Submission for Deadline 5

Written Summary of Oral Case (ISH4) - Onshore Environment, Construction, Transport and Operational Effects Wednesday 20th January 2021

Submitted by Richard Cooper (Lead for Marlesford Parish Council on Infrastructure Projects)

TITLE
MARLESFORD MITIGATION SCHEME (A12)
PRELIMINARY DESIGN (SHEET 1 OF 2)

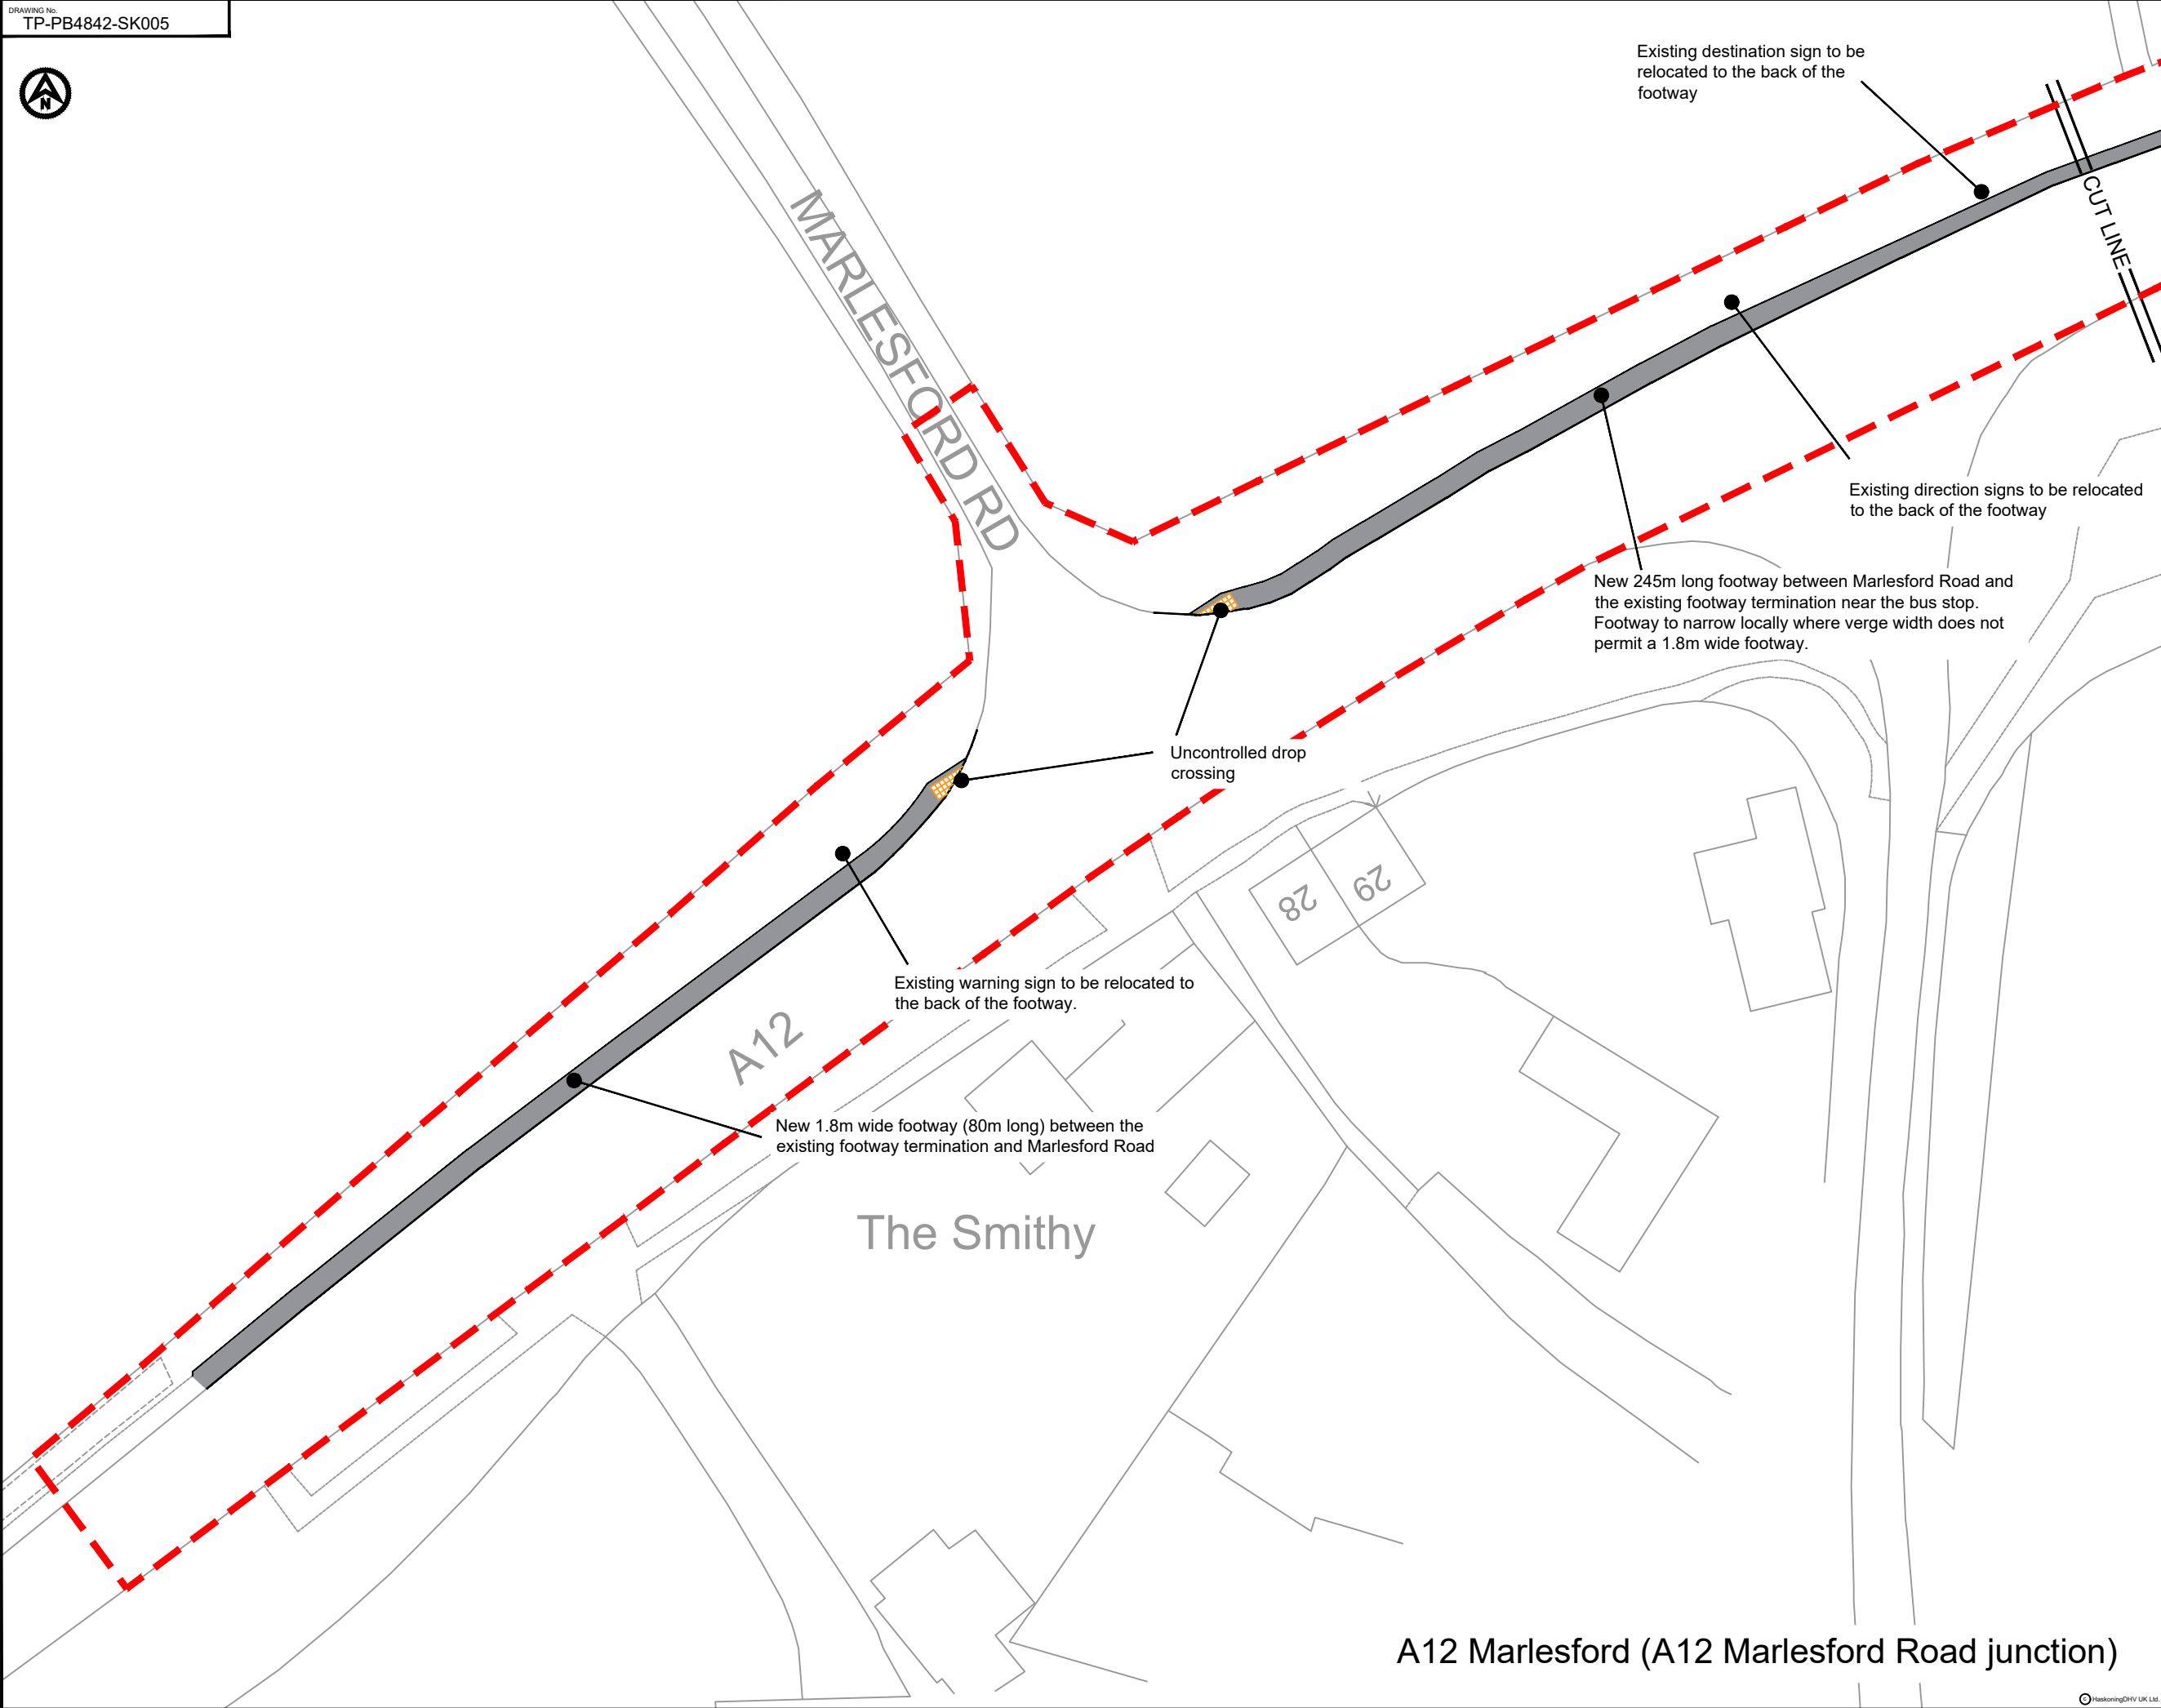
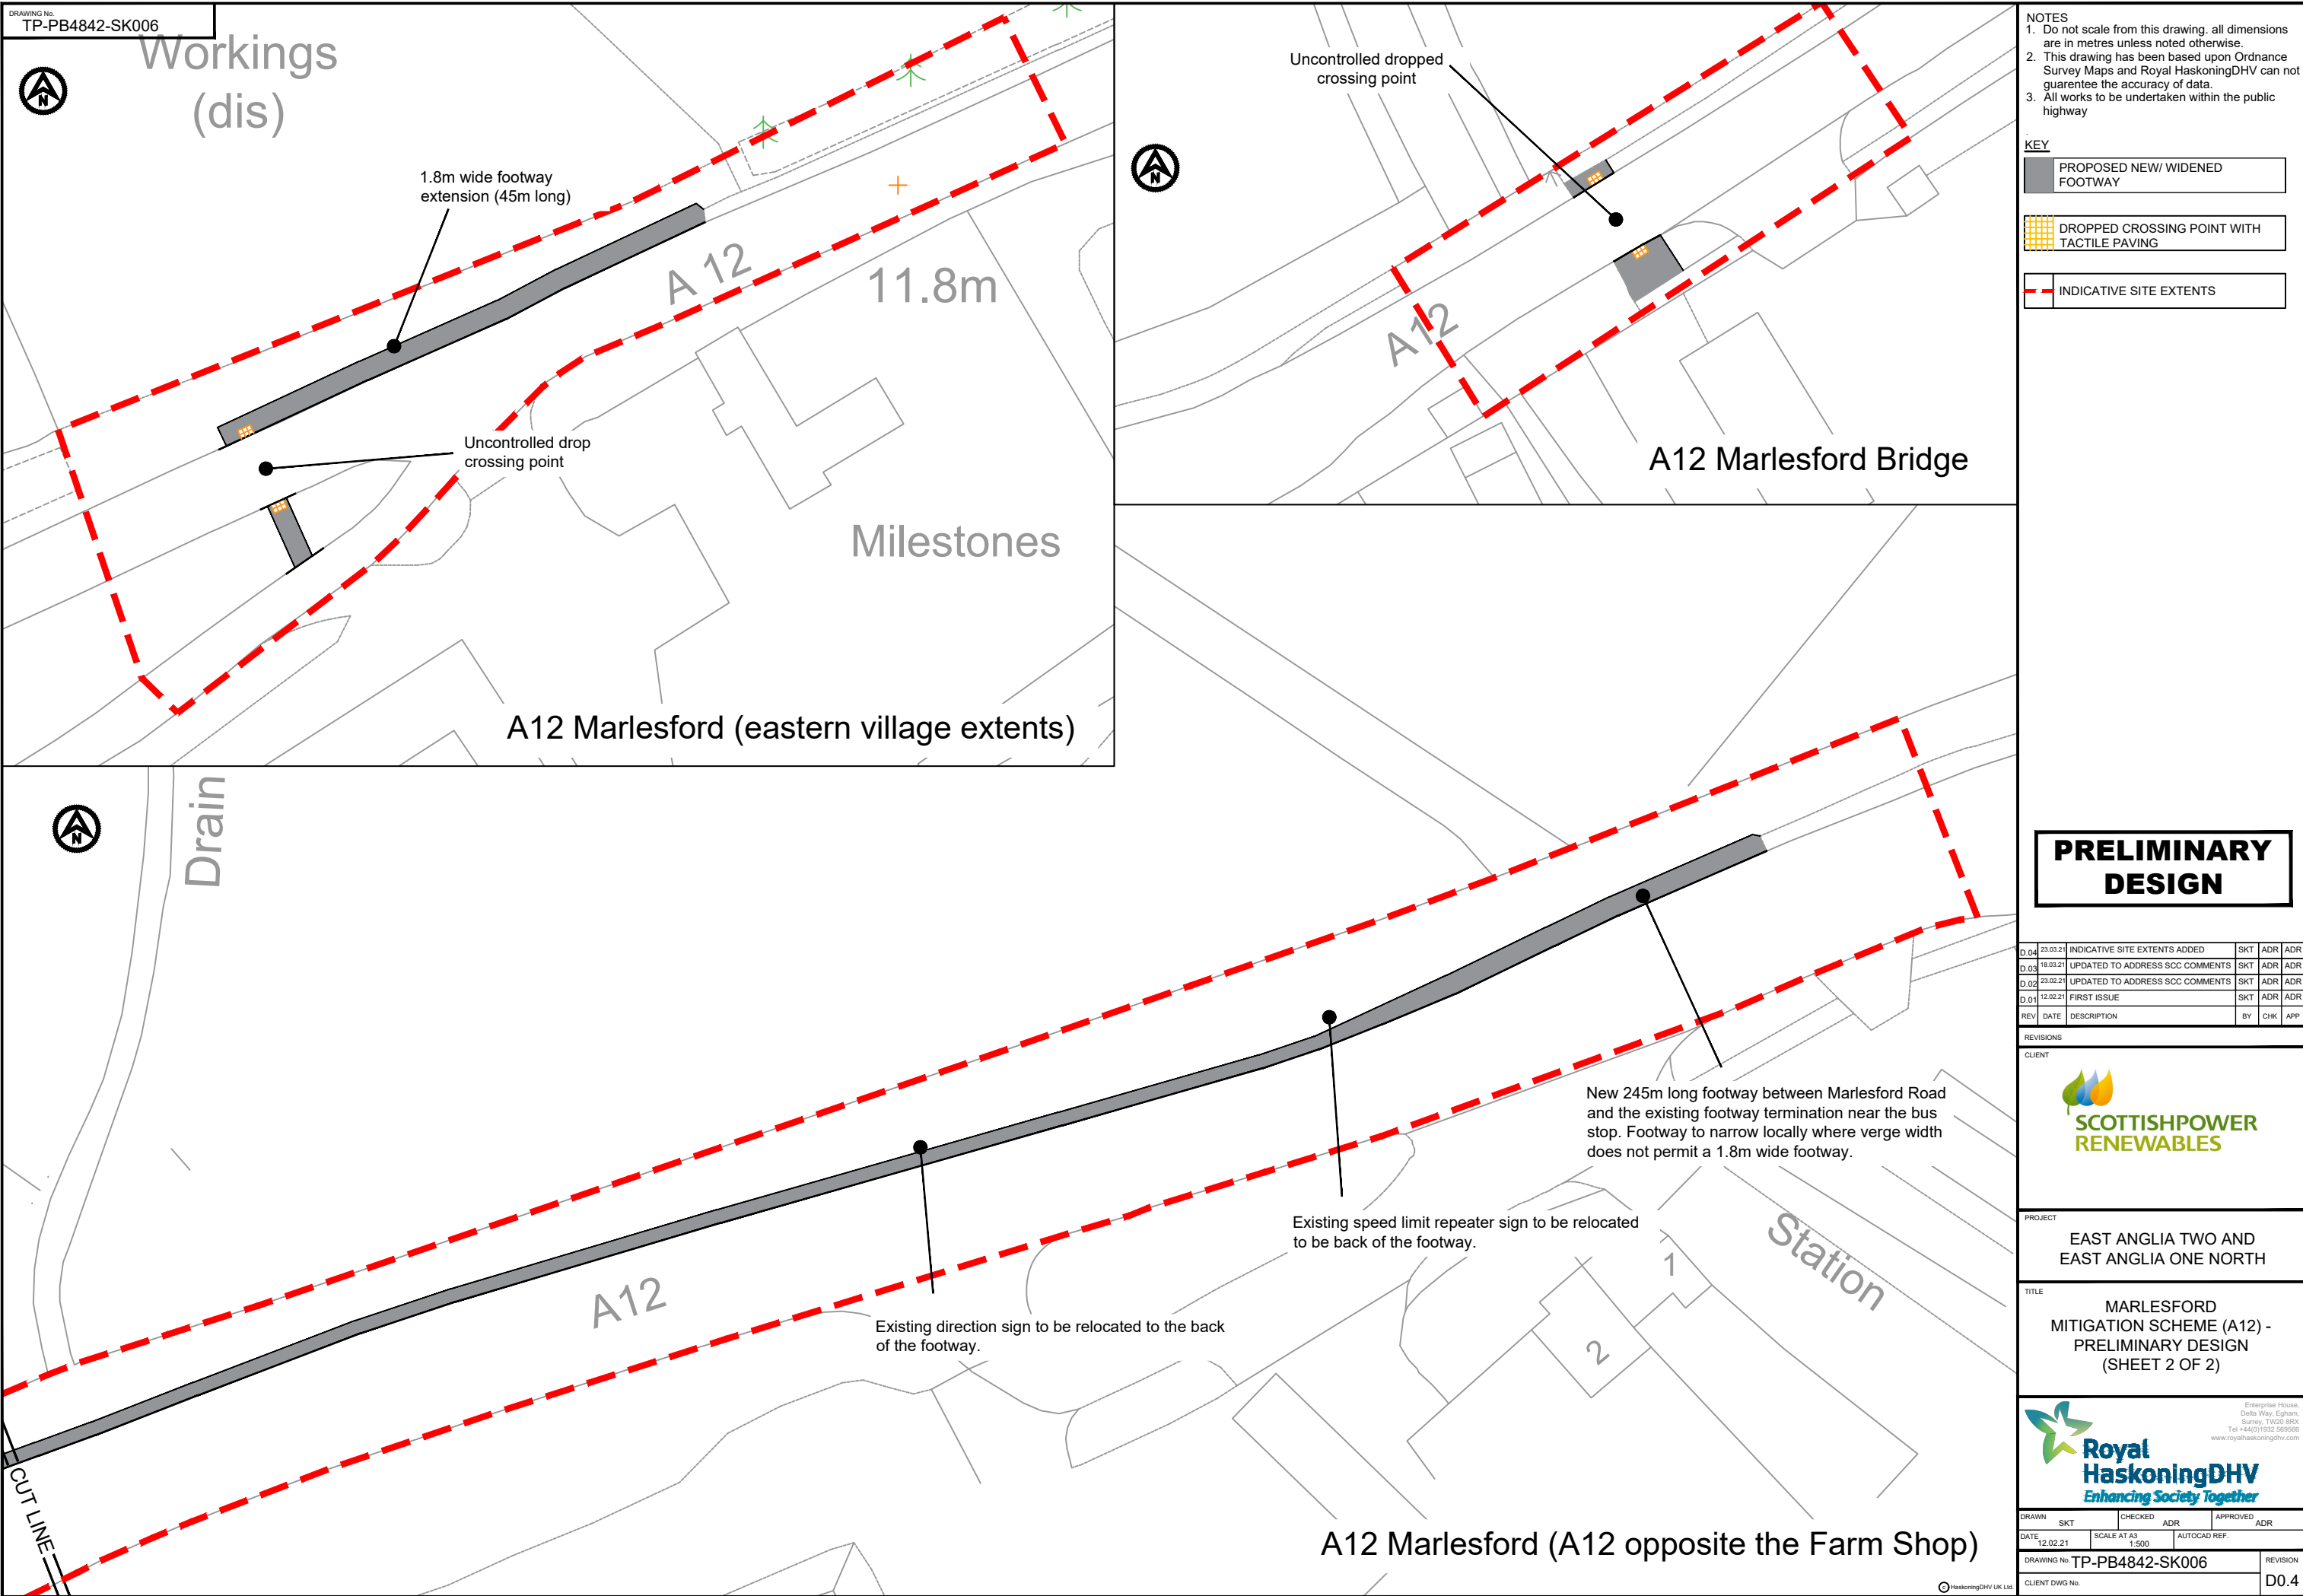
For potentially major road works on the important A12 this seems to be a woefully inadequate level of detail and at no point in the DCO Document is it clear whether these

works are to proceed or not. If the works were to proceed as outlined, there is likely to be a compulsory purchase of the land required for lay-down. To date no approach has been made to the landowner concerning such a purchase.

The need to widen and strengthen Marlesford Bridge only arises if AILs cannot be brought into Belvedere Yard, Lowestoft. If this facility were available, then AILs would approach Friston from the north, thus avoiding Marlesford Bridge. I would urge the Examining Authority to closely assess whether this option has been properly evaluated before the Marlesford site is chosen, as the traffic disruption to the A12, at a time when SZC traffic may also be using this stretch of road, will be considerable. There is no indication of whether the A12 would have to be closed in order for the Marlesford Bridge works to be carried out, but this would lead to huge congestion as the only way to bypass the bridge is a circuitous diversion through narrow country lanes. This option would not be acceptable to either local residents or other users of the A12.

I ask the ExA to urgently request further and better detail from the Applicant on its intentions for all aspects of its possible works to Marlesford Bridge.
